Our ref: WA/2021/129035/01-L01
Your ref: 20/03619/F
Date: 21 July 2021

Construction of attenuation basin including associated infrastructure and landscaping

Heyford Park, Camp Road, Upper Heyford, OX25 5HD

PHASE 9, HEYFORD PARK - ATTENUATION BASIN LOCATION PLAN

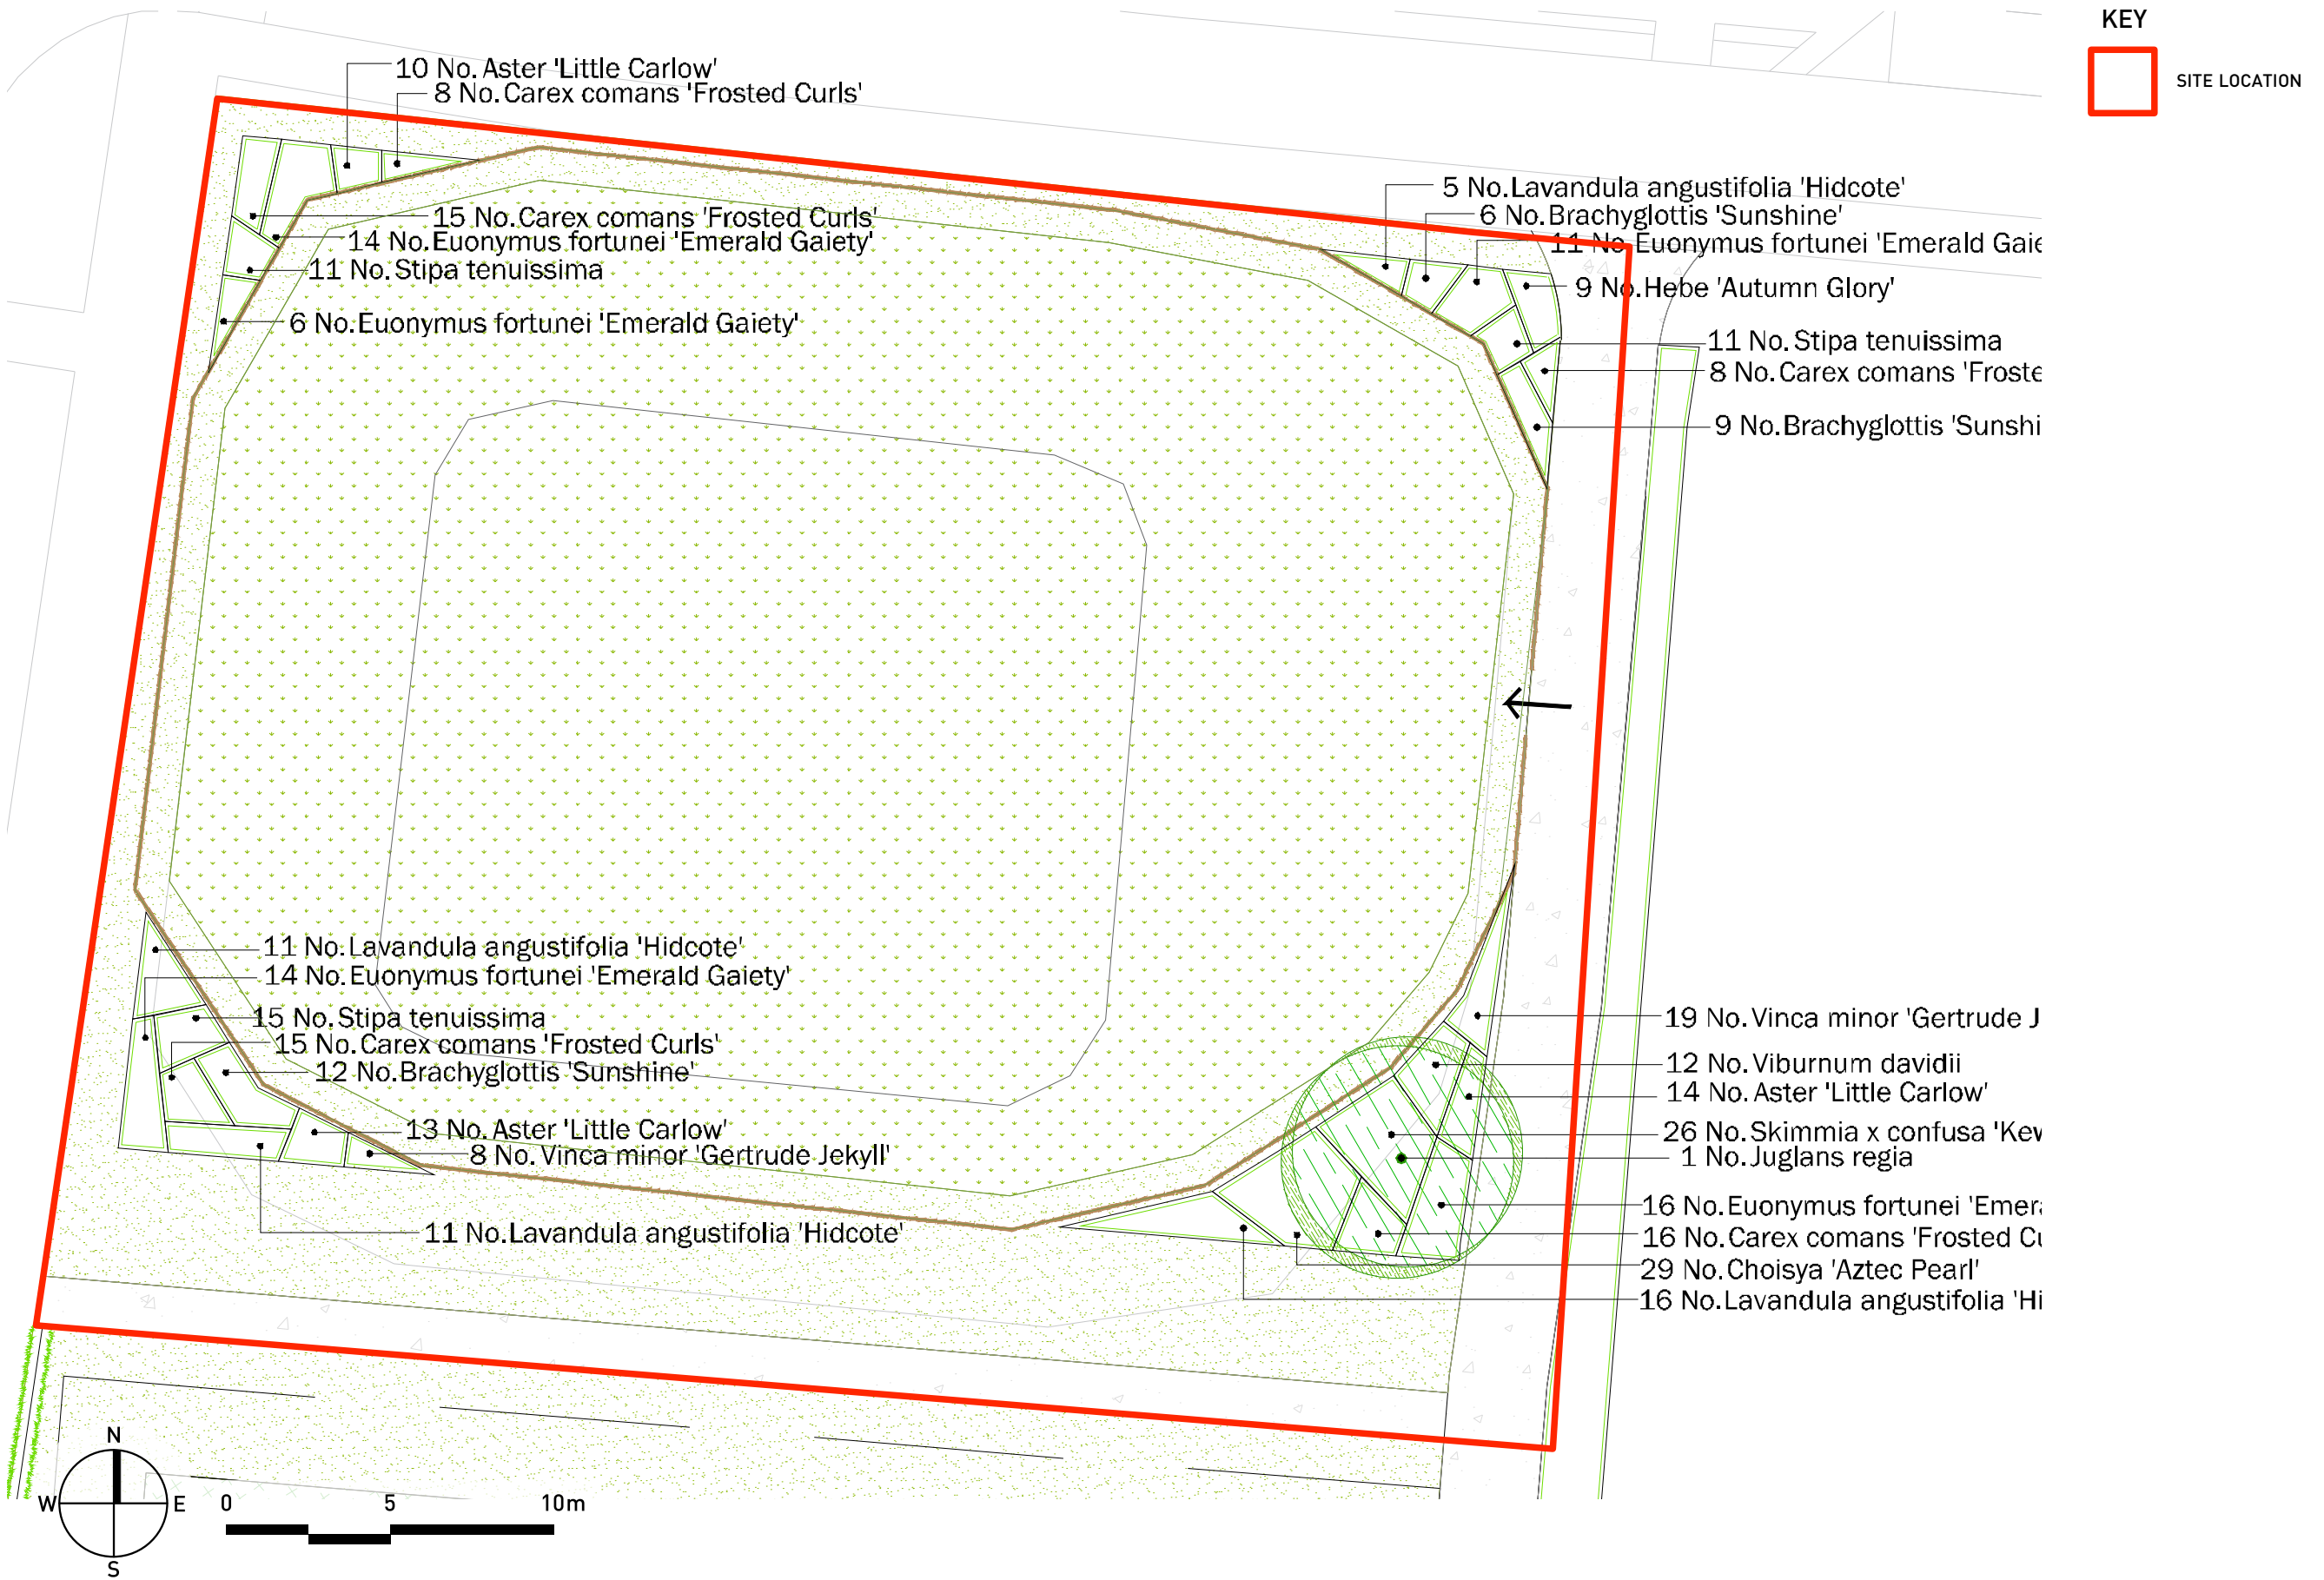
The location of the proposed attenuation basin appears to be on land which historically may have contained part of a runway. While a desk study submitted for a related application covers this area, ground investigations in this location have not been carried out. The application therefore has not demonstrated whether any contaminated land is present in this location.

Any proposal to infiltrate through the attenuation basin will need to be supported by site investigations to demonstrate that infiltration will not result in pollution of the wider water environment.

If, during development, contamination not previously identified is found to be present at the site then no further development (unless otherwise agreed in writing with the local planning authority) shall be carried out until a remediation strategy detailing how this contamination will be dealt with has been submitted to, and approved in writing by, the local planning authority. The remediation strategy shall be implemented as approved.

No drainage systems for the infiltration of surface water to the ground are permitted other than with the written consent of the local planning authority. Any proposals for such systems must be supported by an assessment of the risks to controlled waters. The development shall be carried out in accordance with the approved details.
